# **OXFORDSHIRE COUNTY COUNCIL'S UPDATED RESPONSE TO CONSULTATION ON THE FOLLOWING DEVELOPMENT PROPOSAL**

**Application no:** 14/01932/OUT

**Proposal:** Outline - Development of up to 1,000 dwellings together with a mixed use local centre. [including A1 retail up to 1,000 m2, financial services (A2), restaurants, pubs and takeaways (A3, A4, A5), community uses (D1)]; primary school and safeguarded additional primary school land; secondary school playing field land; green infrastructure including formal (including playing fields) and informal open space, landscape and amenity space; changing and sports facilities (including D2); sustainable drainage systems; highway, cycle and pedestrian routes; car parking; infrastructure (including utilities); engineering works including ground remodelling; demolition, site reclamation and removal of structures. Formation of a new roundabout access from the A361 together with associated alterations to alignment of Bloxham Road and provision of a section of spine road through the site up to its eastern-most boundary

**Date:** 26 July 2016

Appendix G
Proposed Junction Enhancements

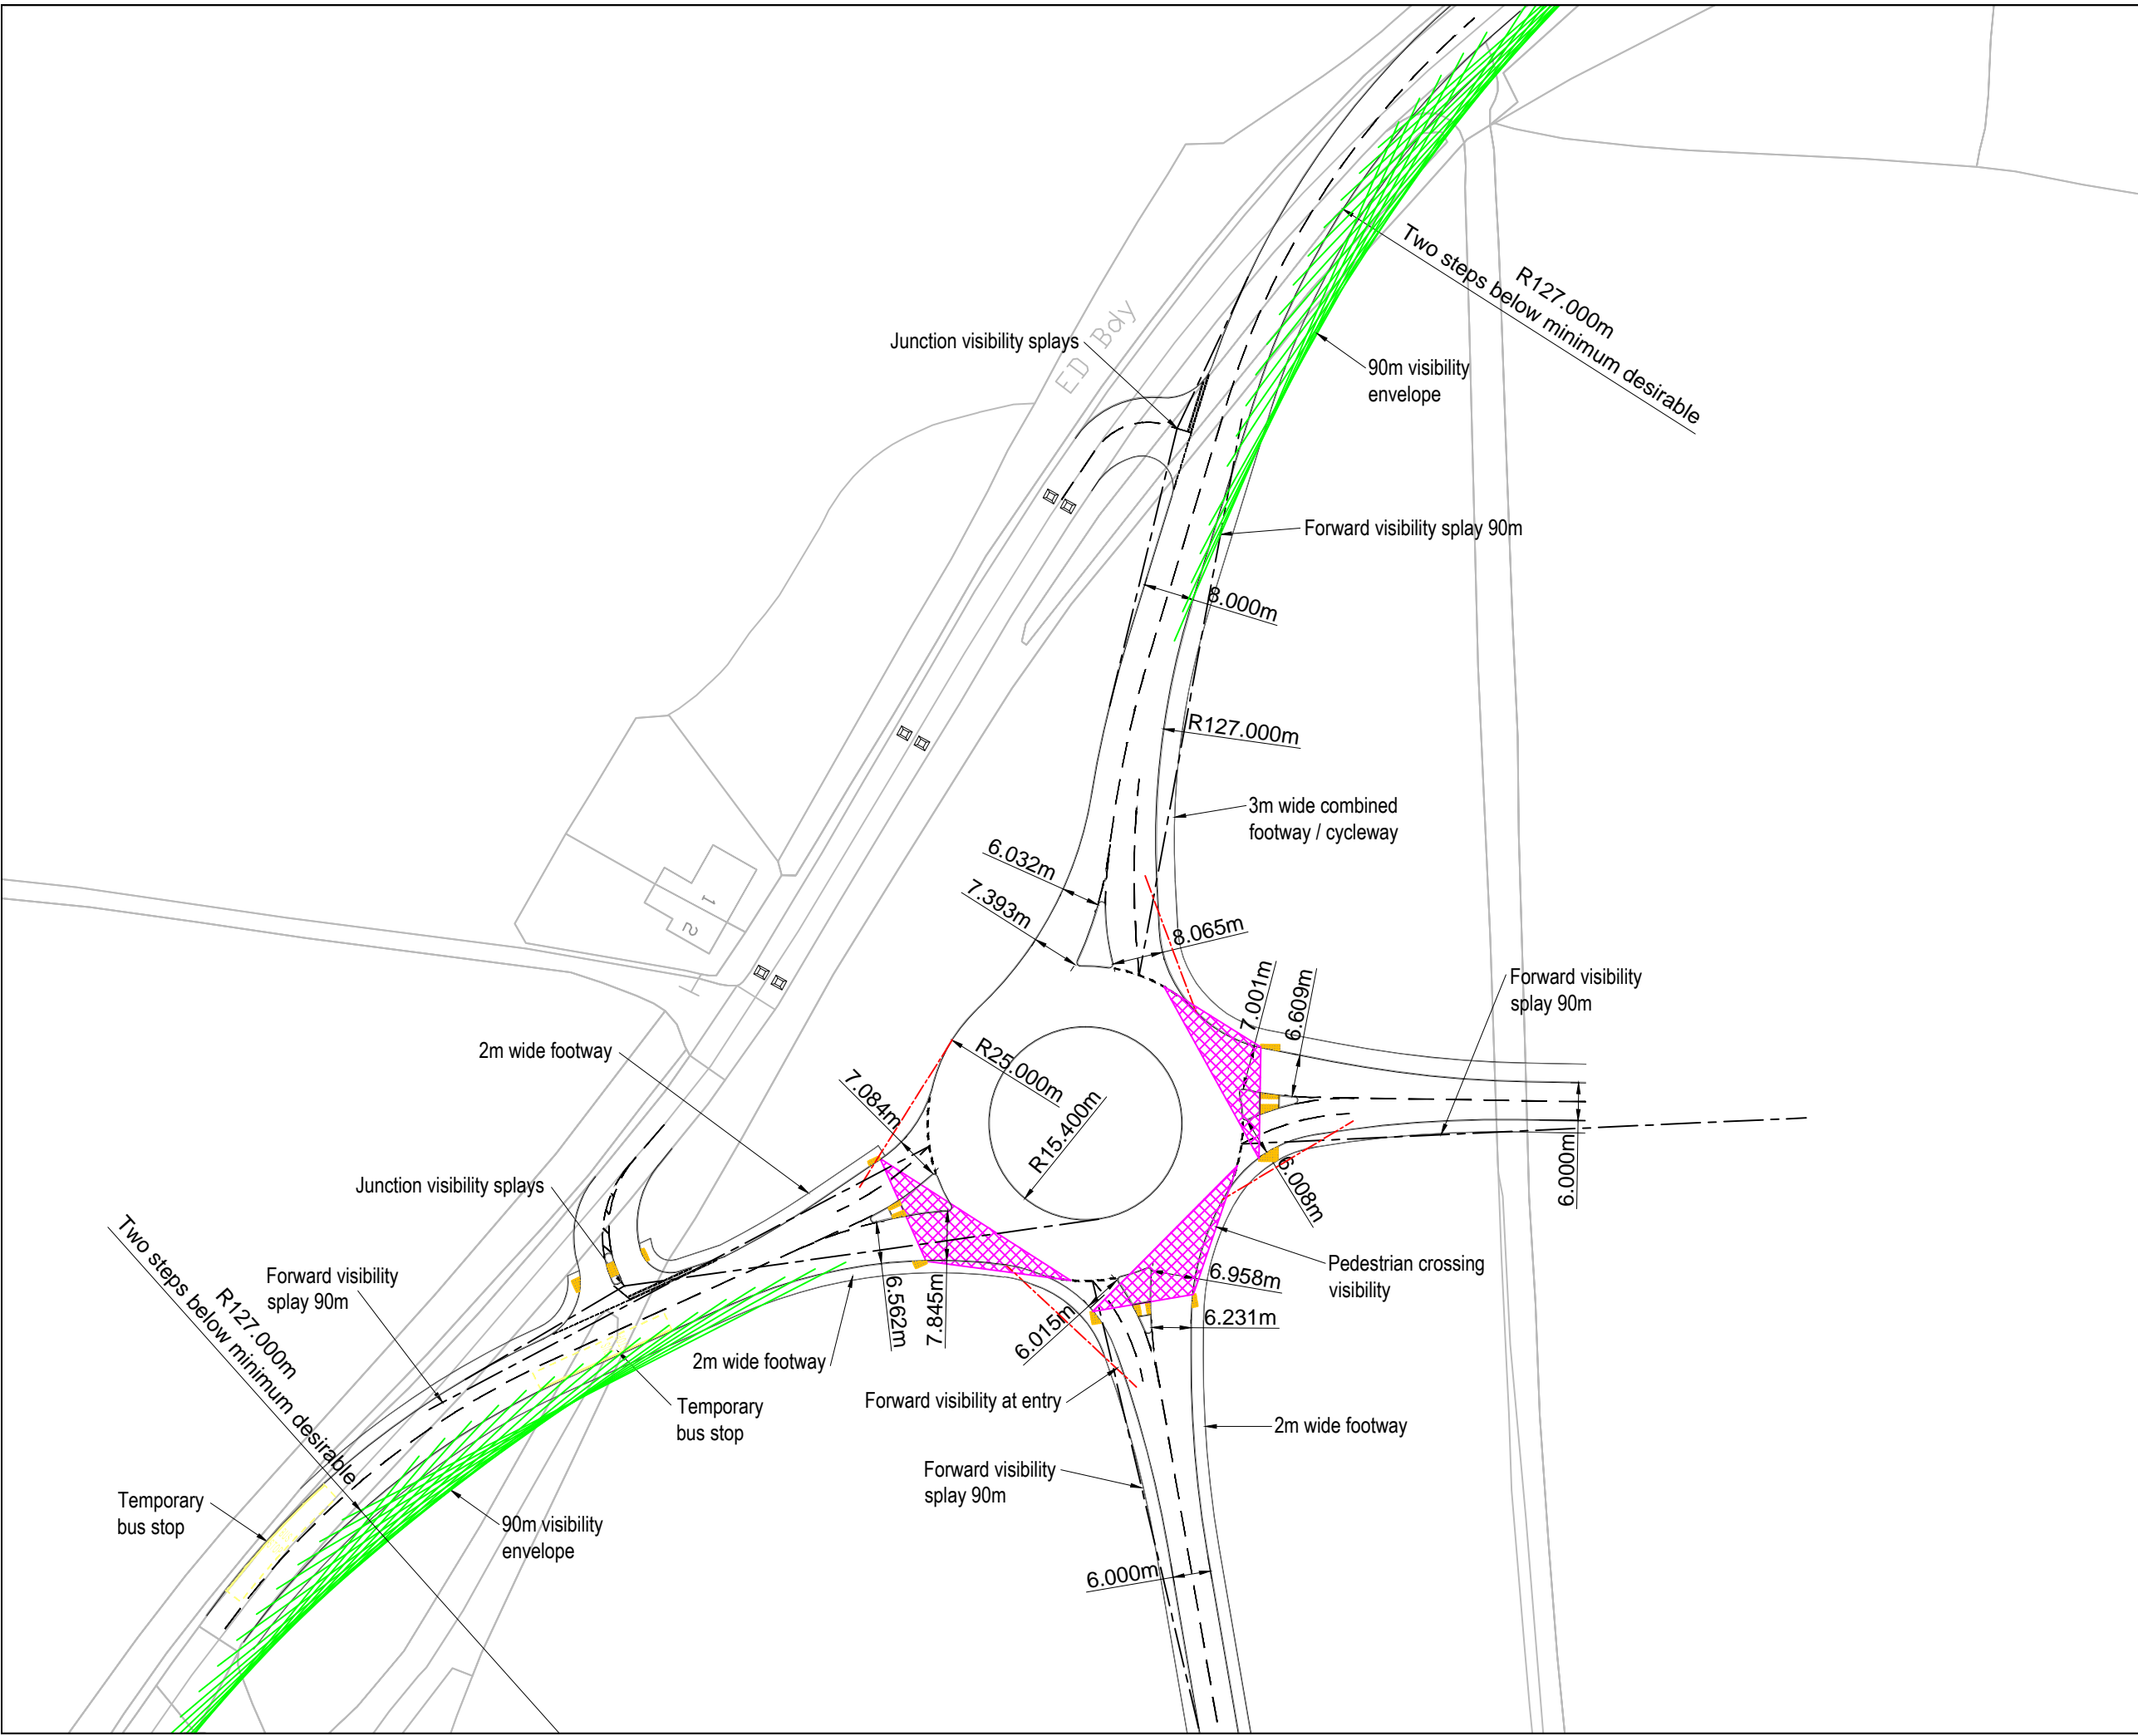
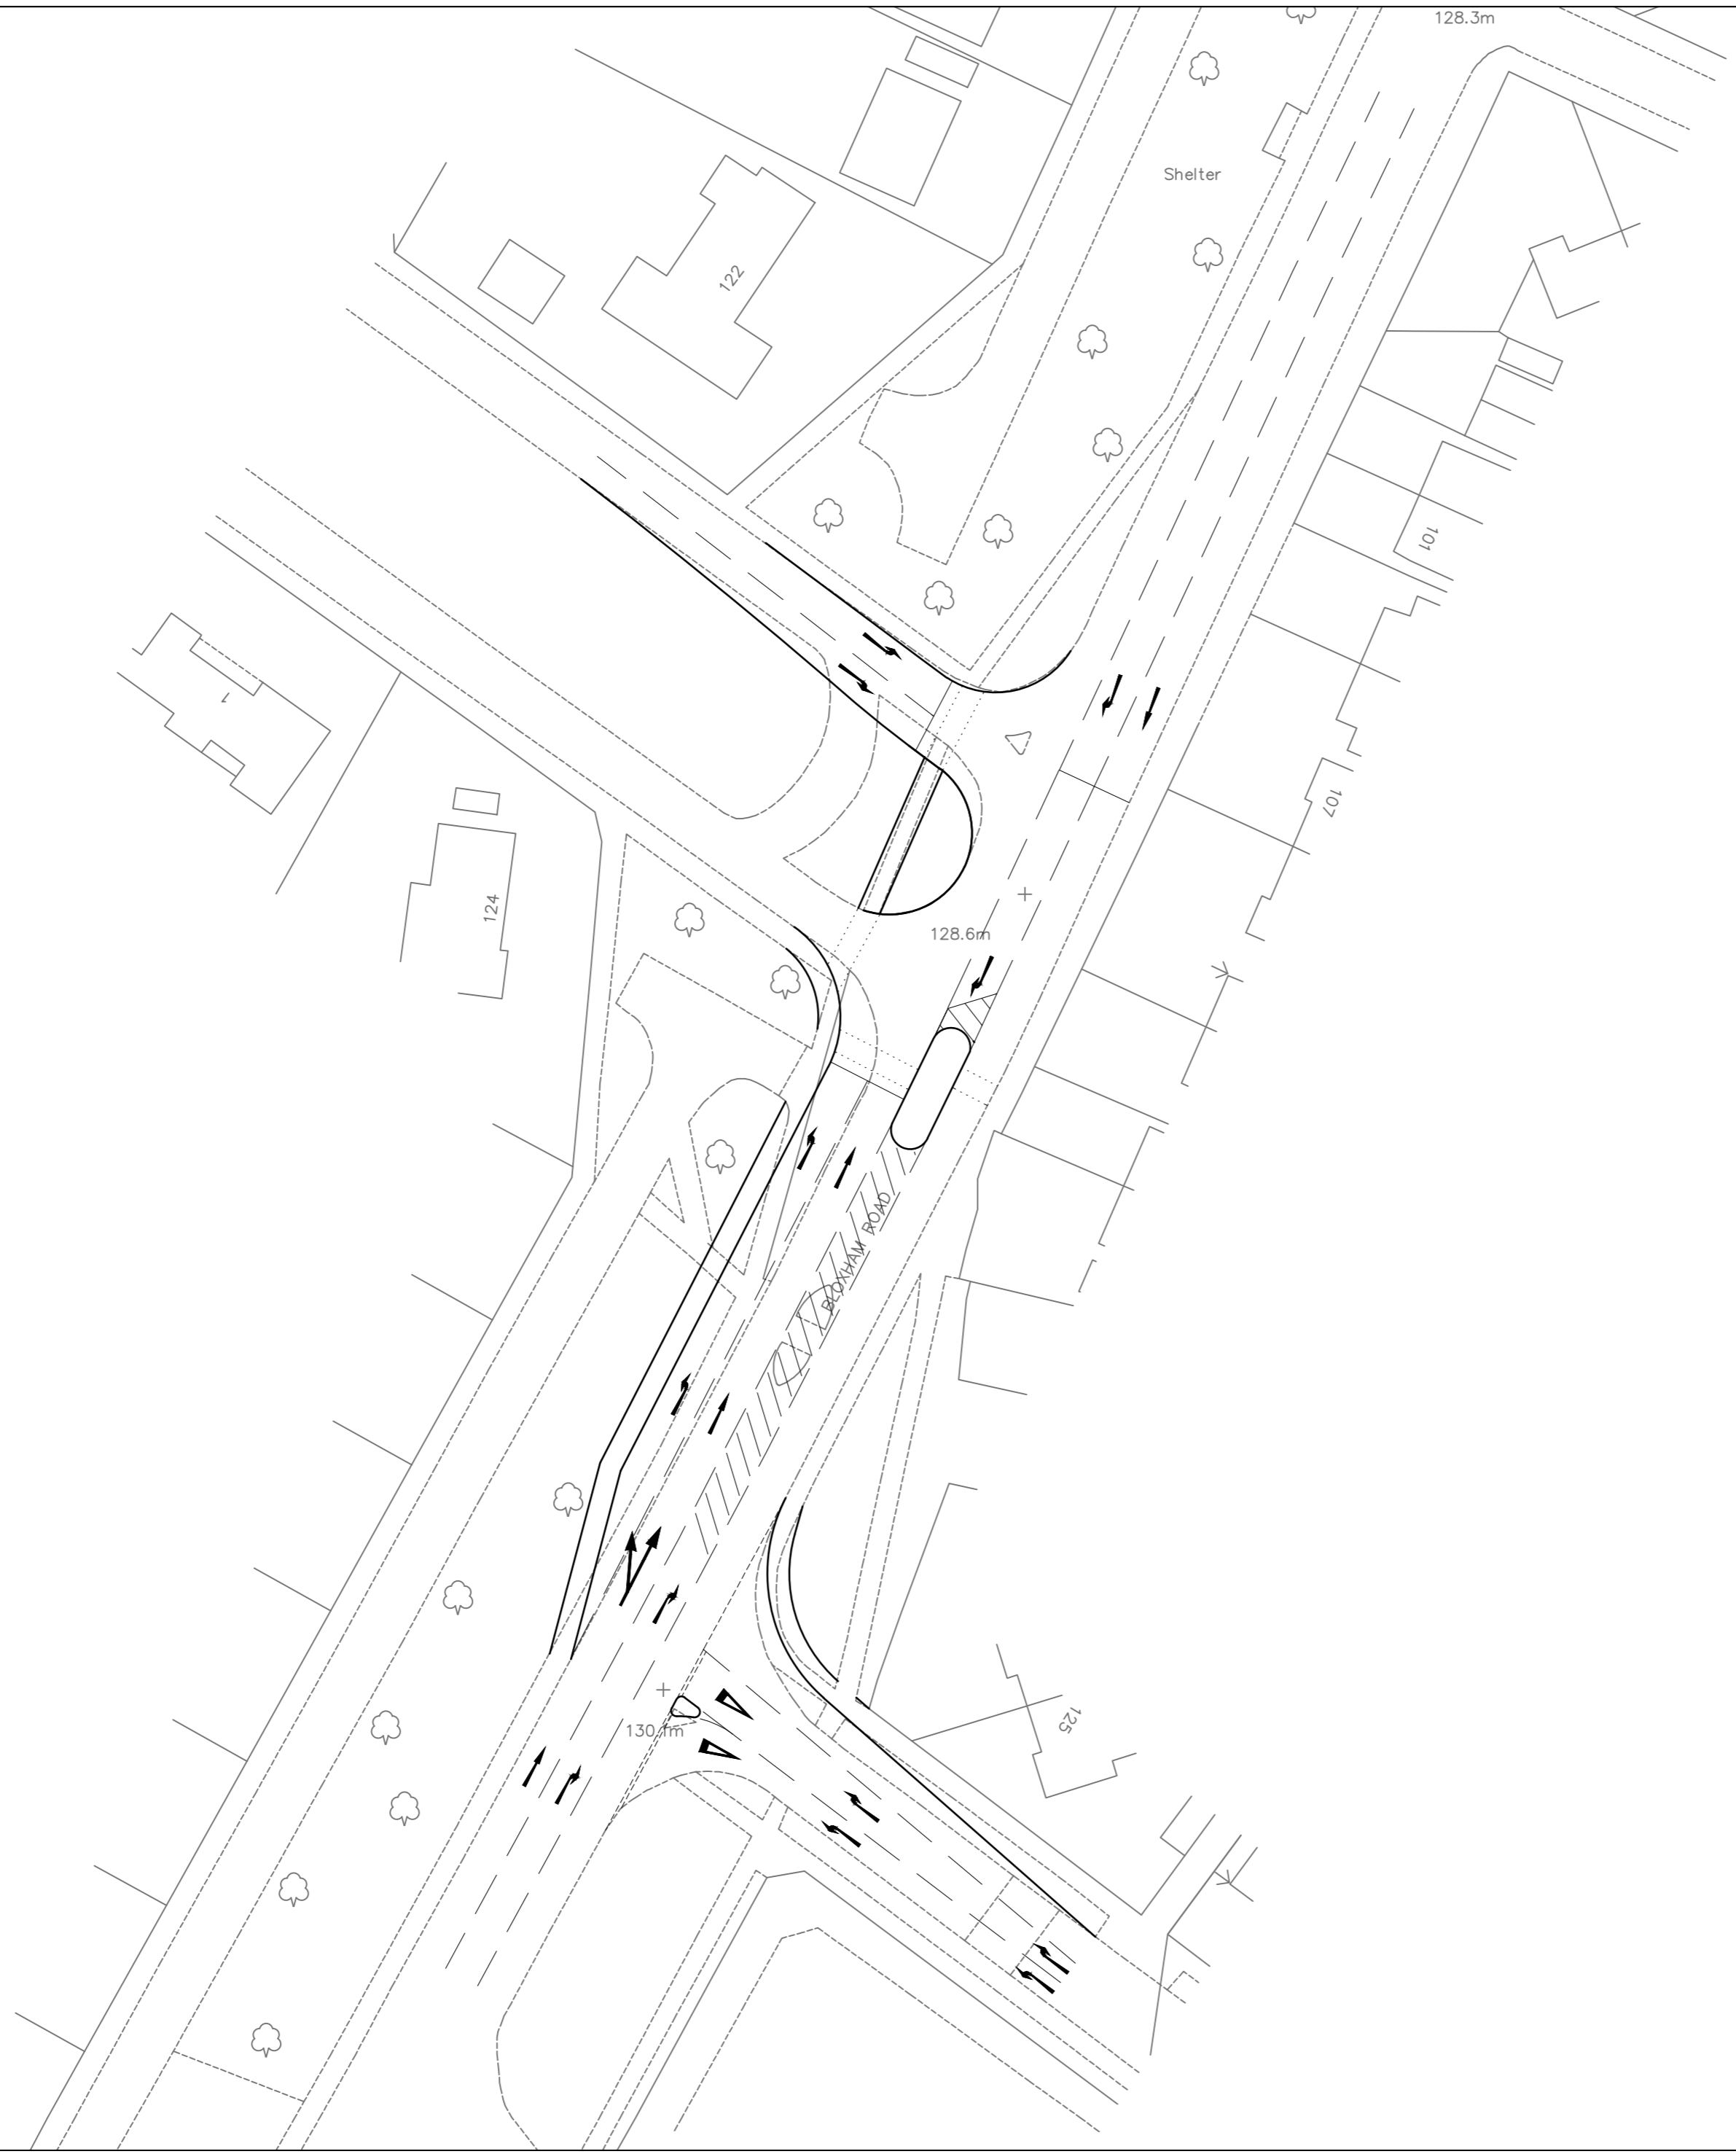
The developer has proposed to implement signalisation of this junction as direct mitigation for the impact of the development. The scheme proposed (Drawing B14129 A\_002 (Appendix G of the Transport Assessment)) may require some slight design tweaks, including better provision for cyclists, to be submitted as part of the S278 application. Works to be completed in advance of the 400<sup>th</sup> occupation of the Gallagher site.

It is acknowledged that development is required to mitigate its own impact and not remedy existing issues on the network. The Springfield Avenue scheme outlined in Drawing B14129 A\_002 (Appendix G of the Transport Assessment) is shown to mitigate the impact of the development and provides betterment of the junction. The council seeks a contribution to the A361 Bloxham Road/Springfield Avenue junction as part of the Strategic Transport Contribution in order for the council to consider in more detail a proposed scheme to benefit the area.
